Consultation Response from: KC Environmental Health (Pollution & Noise Control)

2024/90223 - Netherfield Mills, Calder Road, Ravensthorpe, Dewsbury, WF13 3JS

Change of use from car recycling workshop to skip hire and waste transfer station

Responding Date:
20 March 2024

DRG:  
PROPOSED SITE PLAN

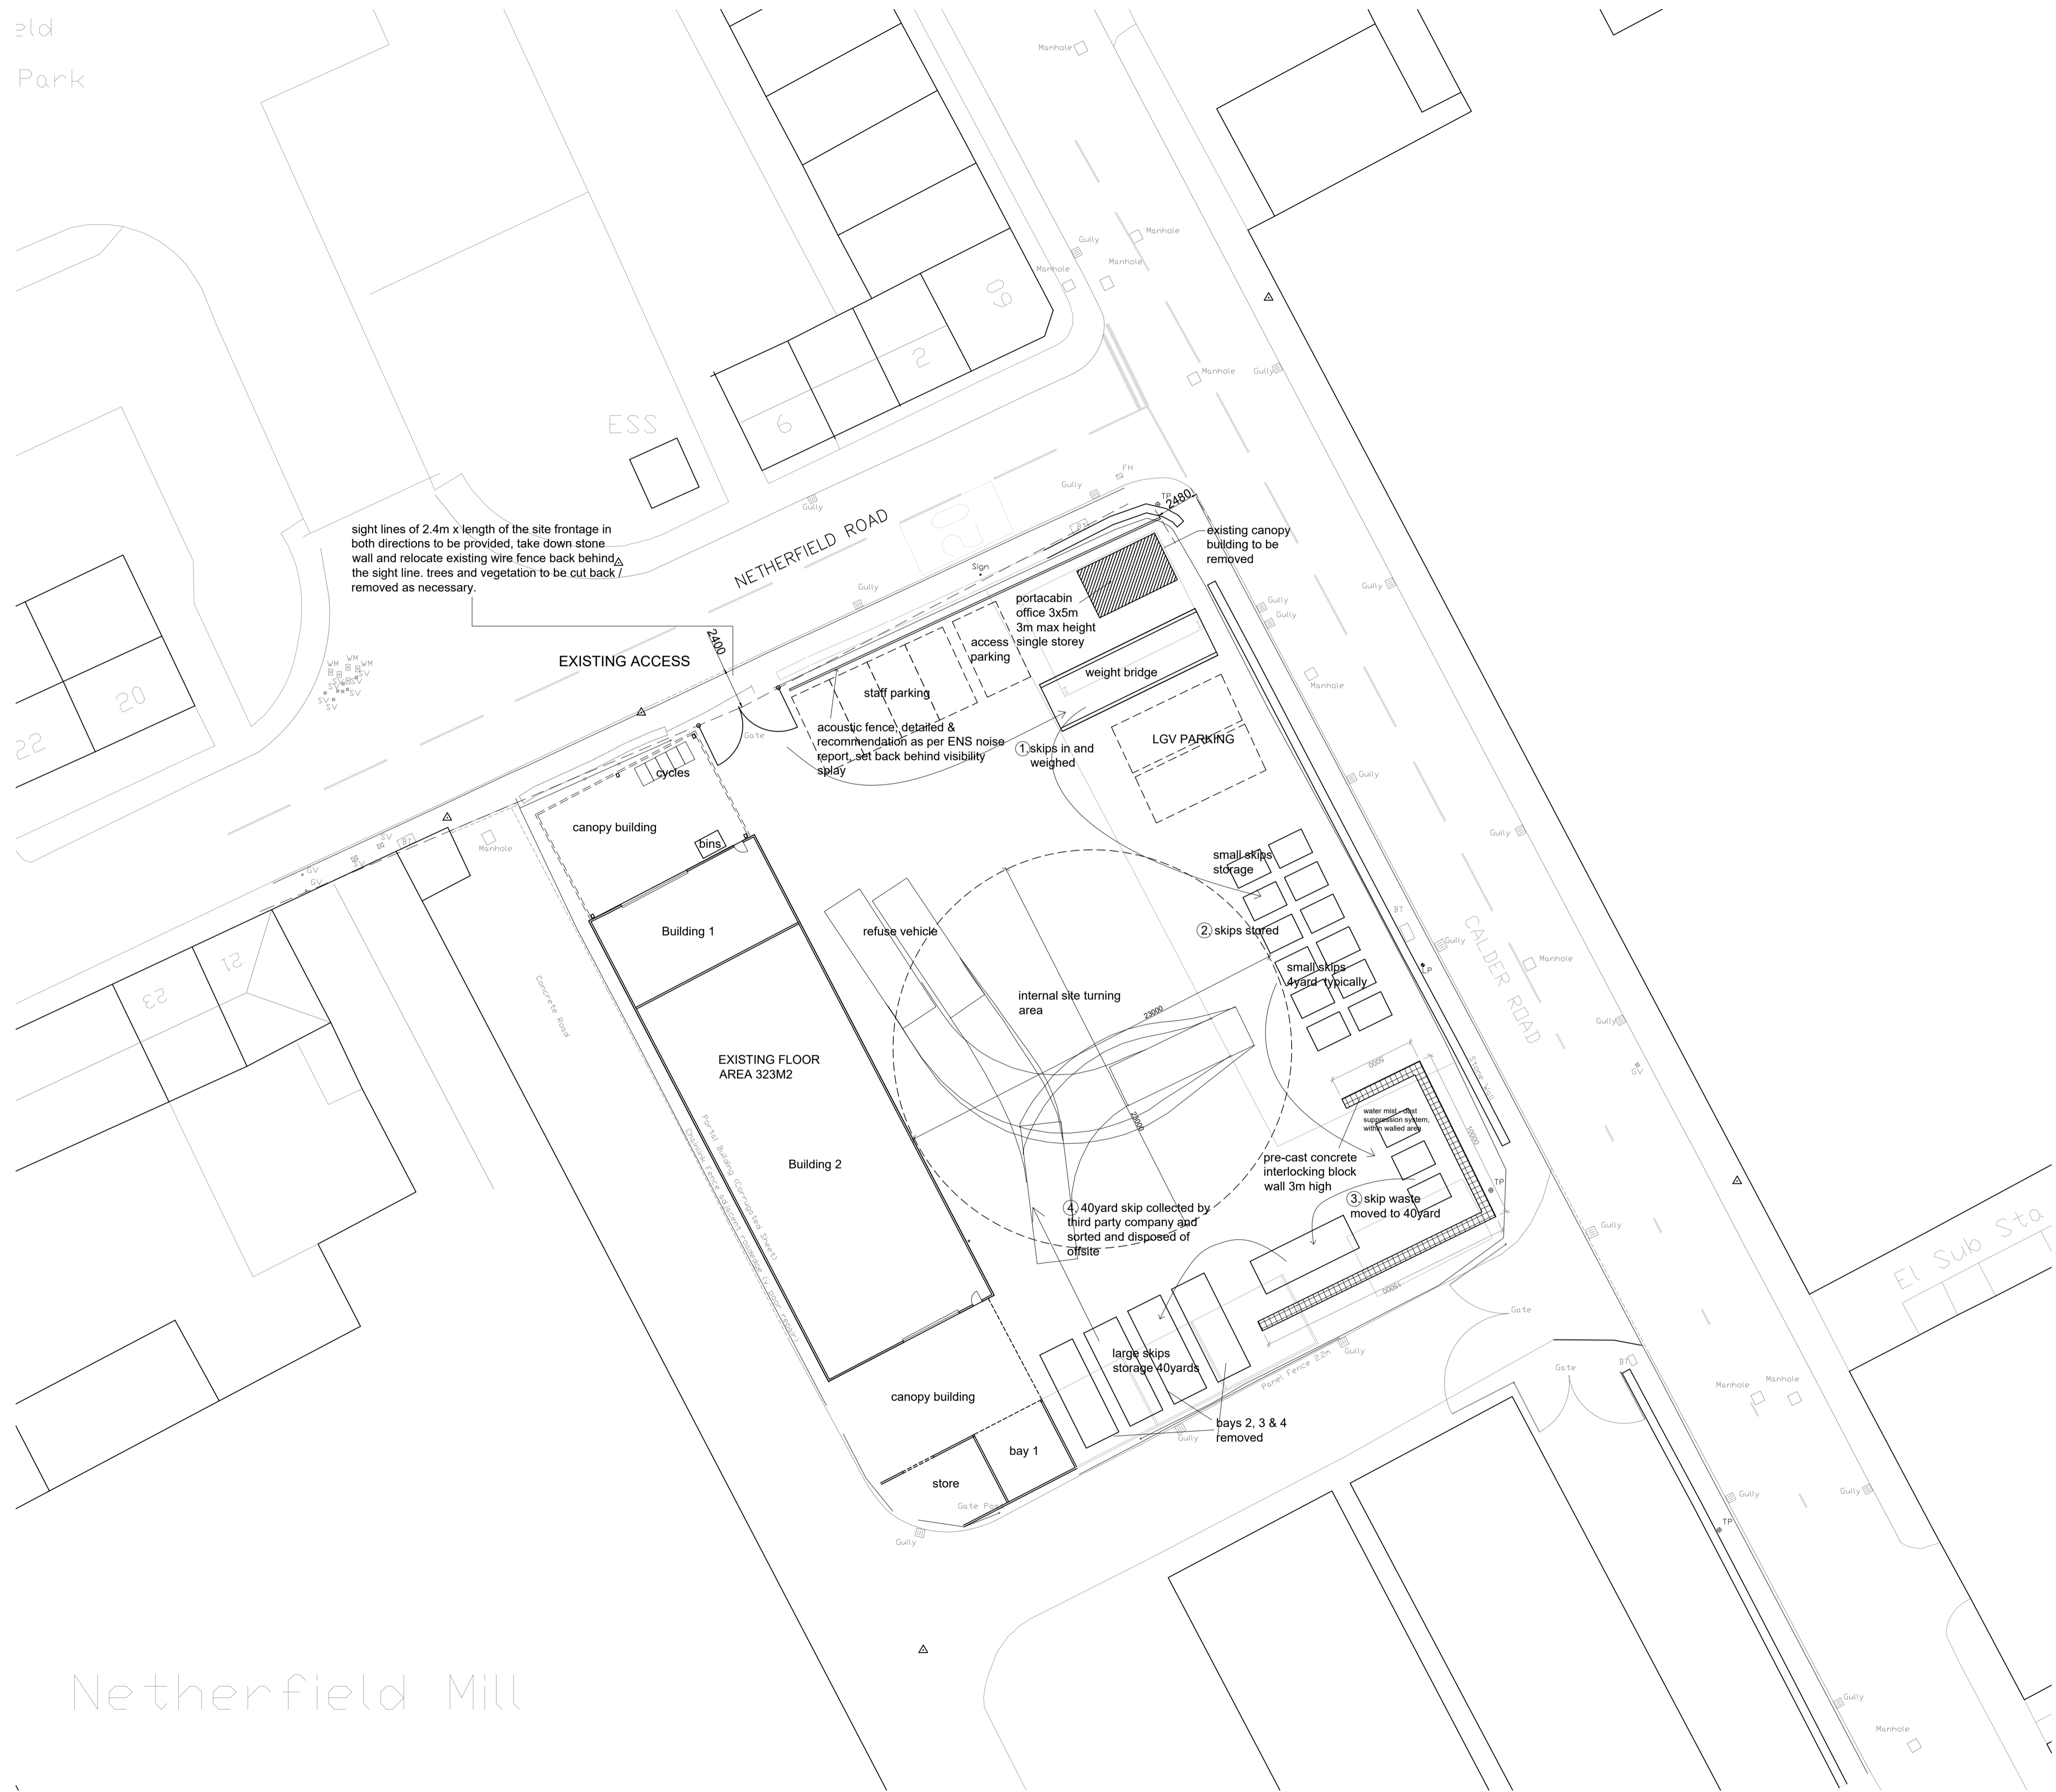
Using library data for a similar site, the assessment considers the daily vehicle and skip movements, recommending a 2.4m high solid timber fence be installed along the northern boundary of the site as shown in Appendix 3. A BS4142 assessment has been conducted, applying a +3dB correction for impulsivity and the results indicate a low impact.

The findings of the report are accepted. However, no detail is given on the use of any fixed mechanical plant. A condition is recommended for the installation of the acoustic barrier and a compliance condition for the use of any fixed mechanical plant to not exceed the measured background levels.

Before the development is brought into use, details of an acoustic barrier as recommended in the Noise Impact Assessment authored by ENS dated 24 January 2024 Ref NIA-11283-24-11493-v1 Netherfield Road, Dewsbury shall be submitted to and approved in writing by the Local Planning Authority. The details shall include:

- A plan showing the location of the barrier
- The minimum height of the barrier relative to the adjacent ground level
- The construction specification of the barrier including the barrier support structure, the barrier material, the minimum barrier thickness, the minimum density of the barrier material and the details where the barrier meets the ground.

The use hereby approved shall not commence until the construction of the acoustic barrier has been completed and the barrier shall be retained thereafter.
